**From:** Amanda Scholes on behalf of Planning.Responses  
**Sent:** 04 January 2018 10:57  
**To:** Planning Scanning  
**Subject:** FW: AL/115/17/OUT - Proposed development of 55 homes - Land at Wings Nursery, A29 Lidsey Road, Woodgate - WSCC Highways response dated 4th January 2018  
**Attachments:** AL 115 17 OUT response 2.docx

**WEST SUSSEX COUNTY COUNCIL  
PLANNING SERVICES CONSULTATION**

**SUBJECT: AL/115/17/OUT - Outline application with some matters reserved for the erection of 55No. dwellings, sustainable drainage measures, public open space, children's play area, landscaping & all other associated works. This application is a Departure from the Development Plan.**

**LOCATION: Wings Nursery, Lidsey Road, Aldingbourne, PO20 3SU.**

Figure 2.6: PIA Distribution

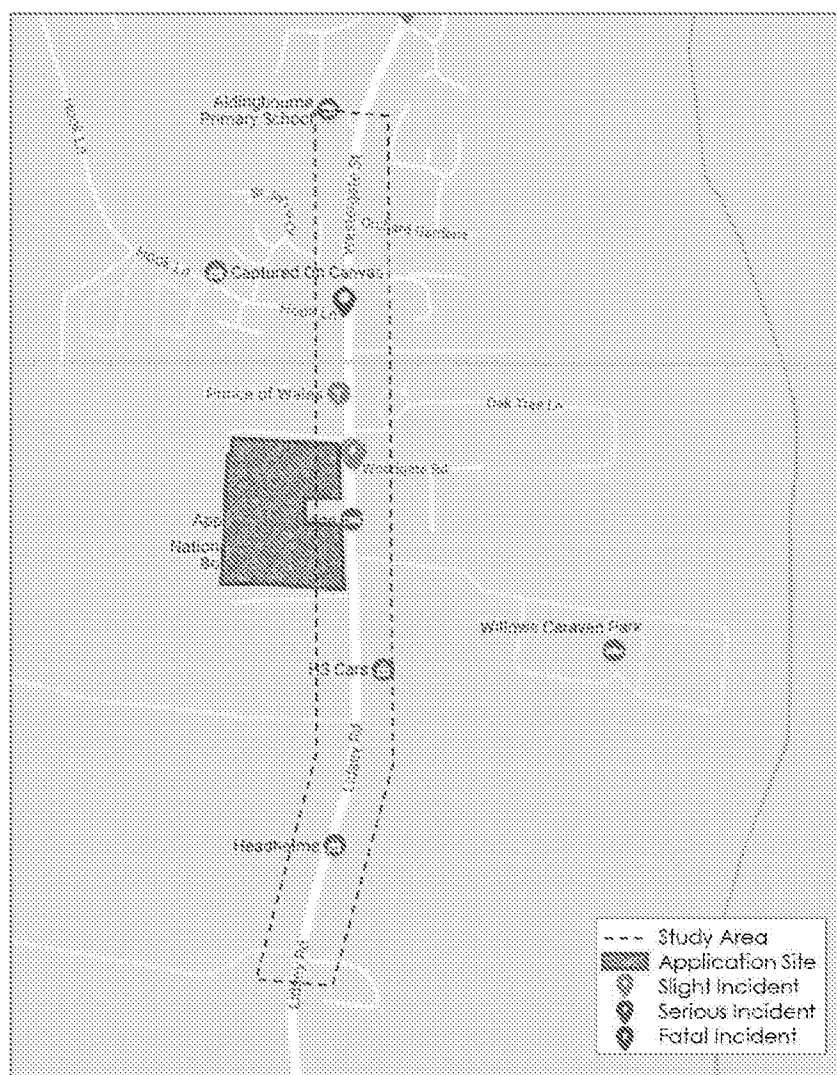
Three PIAs have occurred along this stretch of the A29 using data taken between 2009 and 2014. It is not known why more recent data hasn't been used. Applicants are required to provide the most up-to-date records. From interrogation of the three recorded incidents in the documentation provided so far, two of these occurred at the junction of Woodgate Road with Lidsey Road with a further (serious) accident at the junction of Hook Lane with Lidsey Road north of the railway crossing. Both of the Woodgate/Lidsey Road accidents resulted in slight injuries being recorded. It should be noted that one of these accidents involved a vehicle travelling on the offside of a stationary queue of traffic as a result of the level crossing being closed in order to turn into Woodgate Road. This supports the Highway Authority's concerns that drivers may experience frustration caused by the queueing caused by the railway crossing closures and possibly undertake manoeuvres that would otherwise not be attempted.

RGP Swept Path Analysis

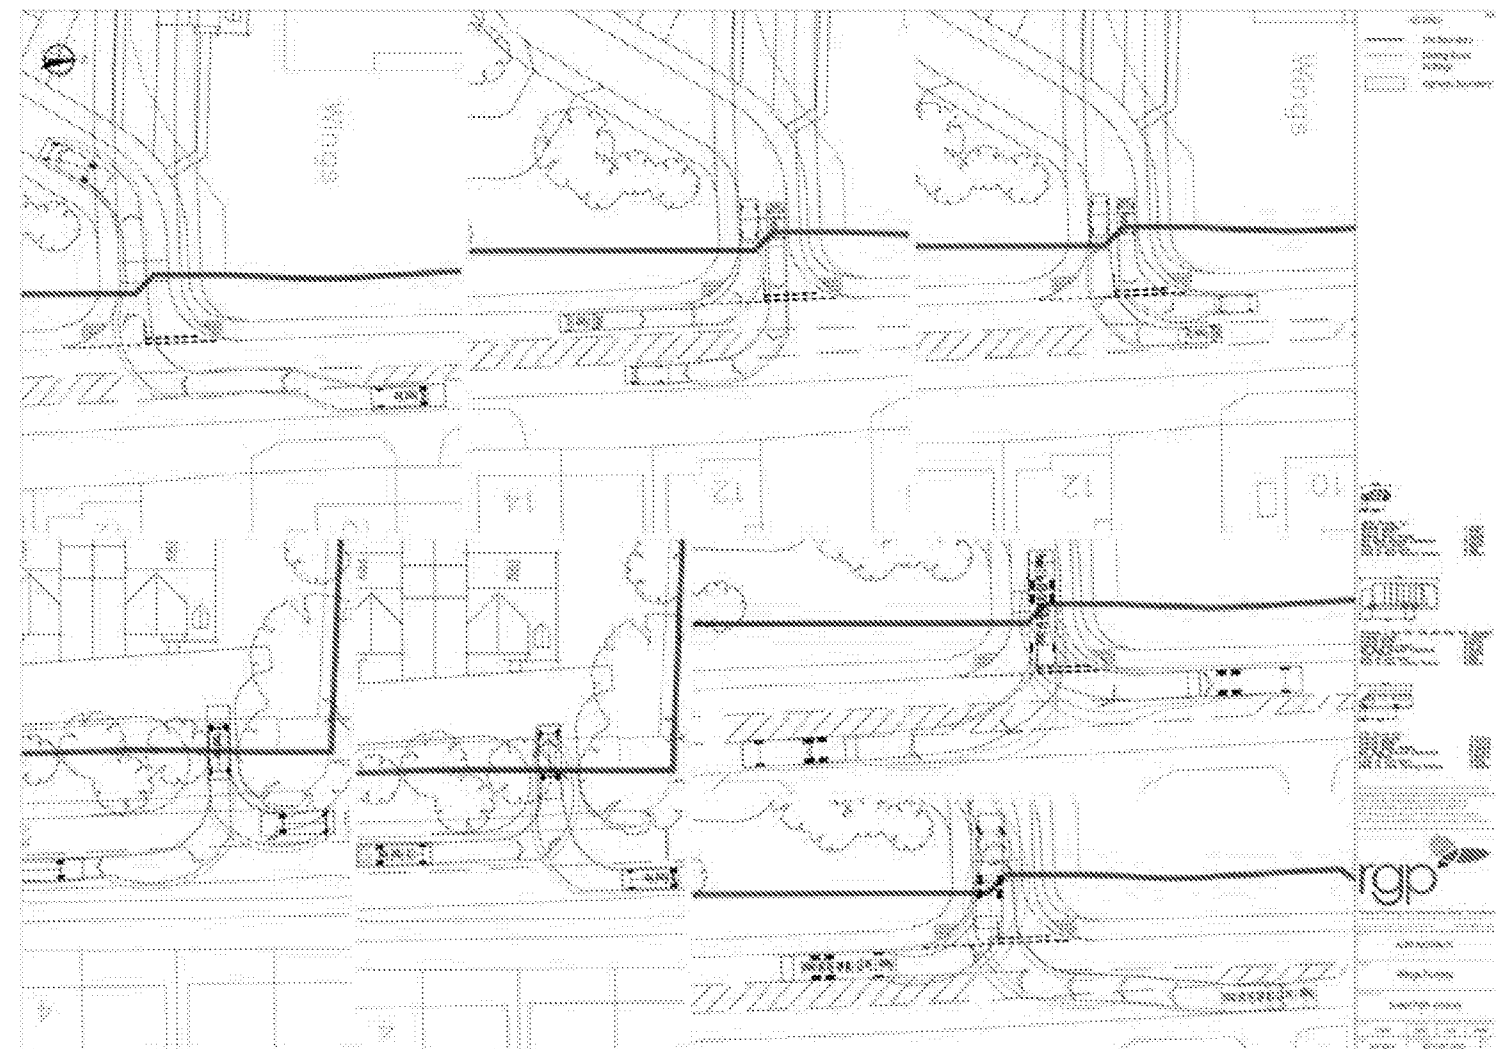
The Highway Authority has reviewed the information provided (including swept-path diagrams of vehicles entering and leaving the junction). Based on that provided, four concerns have been identified. Namely:

2. Large vehicles are required to oversail the centreline of the new access road. If they attempt to do this during busy period when traffic might be blocked because of the queueing extending back from the railway crossing, such vehicles could end-up finding their paths blocked, thereby leading to potential blocking on the A29.
